**Re: PA23-012 – English Crossing Townhomes – Technical Review @**

SUBJECT: PA 23-012 – English Crossing

To: Merle Ash, Land Technologies  
From: Don McGhee, Assistant Fire Marshal  
Date: August 22, 2023  
Subject: PA23-012 English Crossing Townhomes 17406 19<sup>th</sup> Avenue NE

RE: English Crossing, File# PA23-012  
247 New Townhomes  
17406 19<sup>th</sup> Ave NE & Parcel # 31051900401200

SHEET
 P1 of P3
 24x36
 PA 23-12

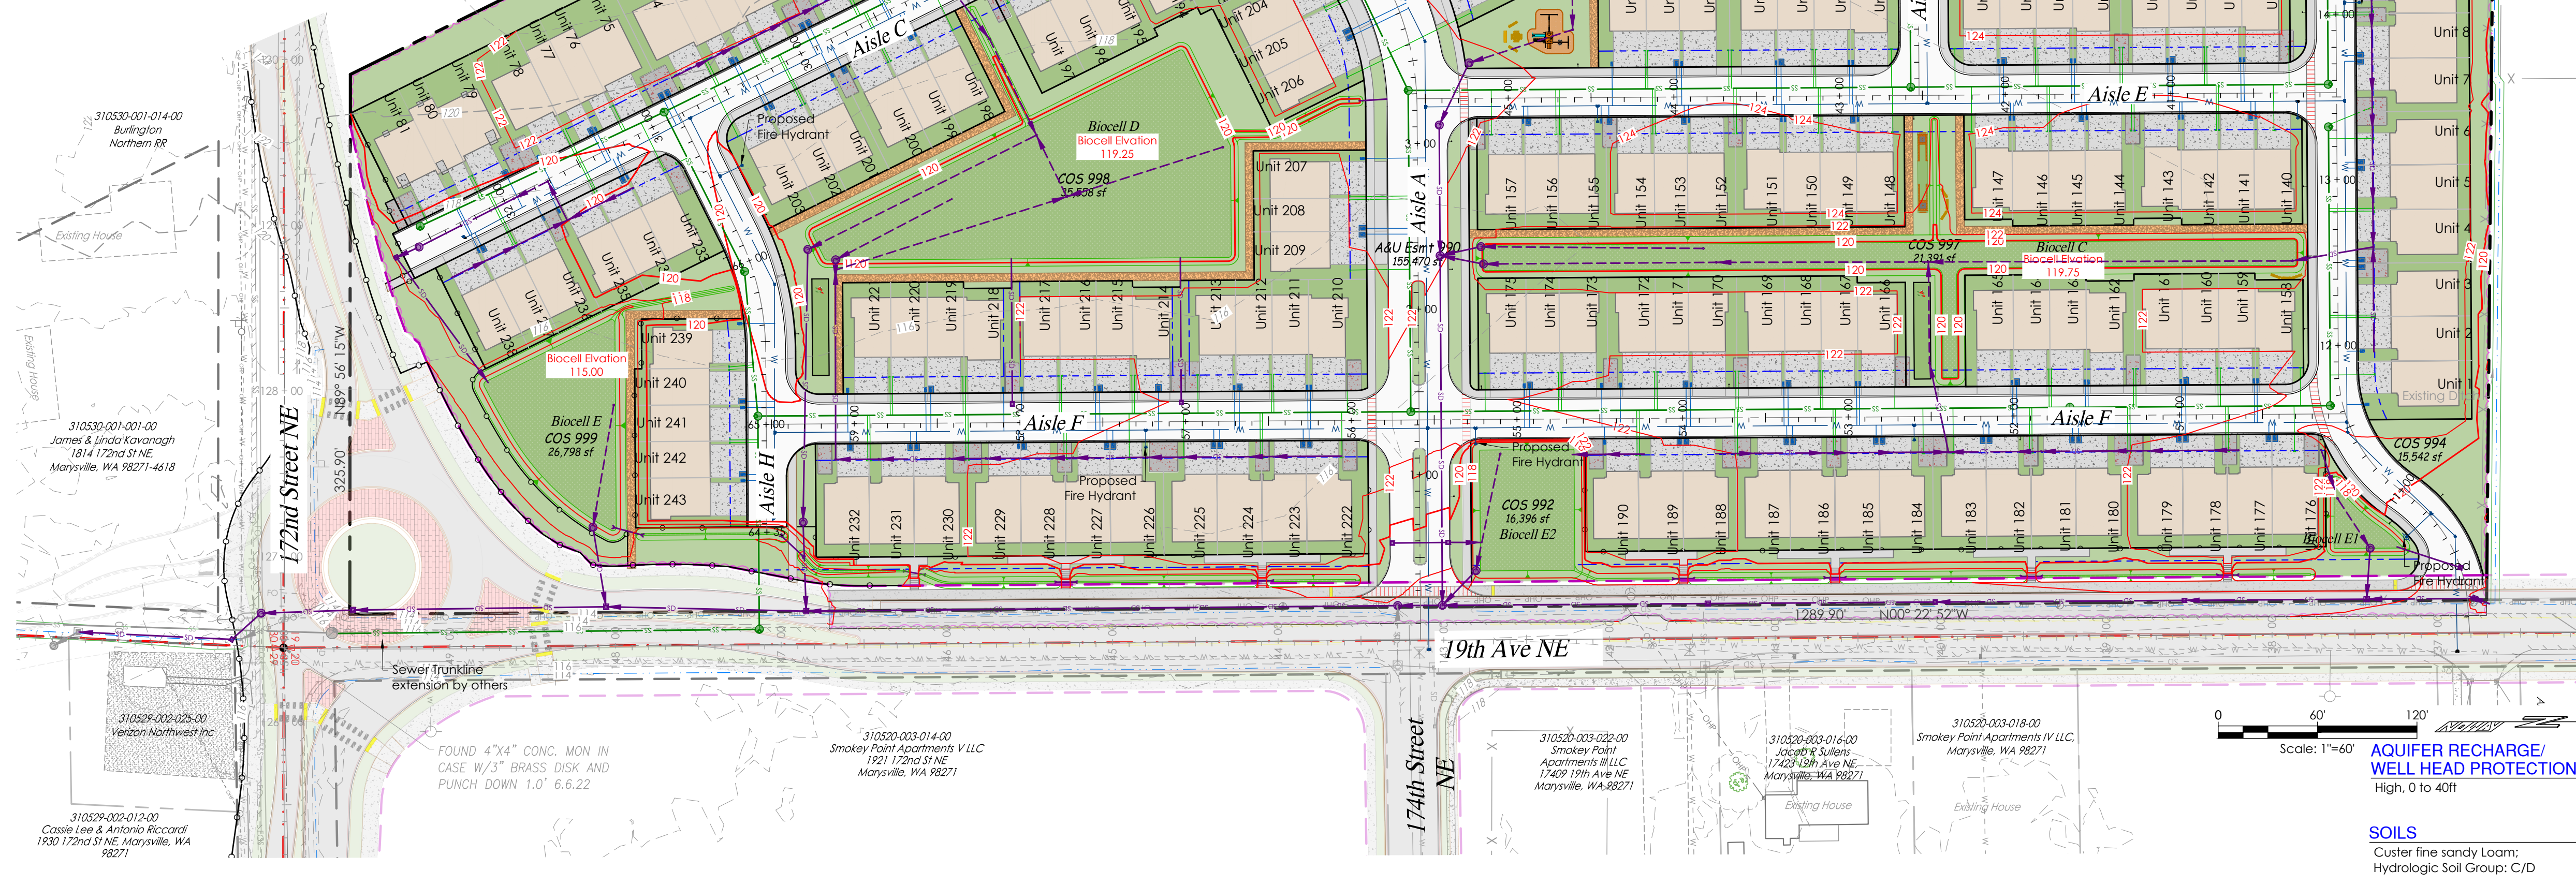
- . Units adjacent to 19<sup>th</sup> Ave. (175-190, and 222-232) shall have the primary entrance oriented towards 19<sup>th</sup> Ave. This is a code requirement and anticipated to be a condition of approval. A landscape buffer in place of this required orientation will not be acceptable as none of the above referenced site conditions make this infeasible, and a landscape buffer does not enliven the streetscape.

5. Pedestrian connections are required from entries of the units adjacent to 19<sup>th</sup> Avenue (Units 175-190, and 222-232). Installation of stairs will likely be needed to address the grade change. These connections shall be depicted on the site plan. This is a code requirement and is expected to be a condition of approval.
6. Consistent with [MMC 22C.065.130](#), Street Connectivity, new development in the mixed use zones shall provide an integrated and connected network of streets to provide “direct” walking route options, orientation, a sense of place, and multiple travel route options. Blocks shall be designed to provide vehicular connections at intervals no greater than 600 feet and pedestrian access at intervals no greater than 300 feet (200 feet is preferred). Please add one additional access from Aisle H, between Units 88 and 89 as shown below, to meet this requirement.
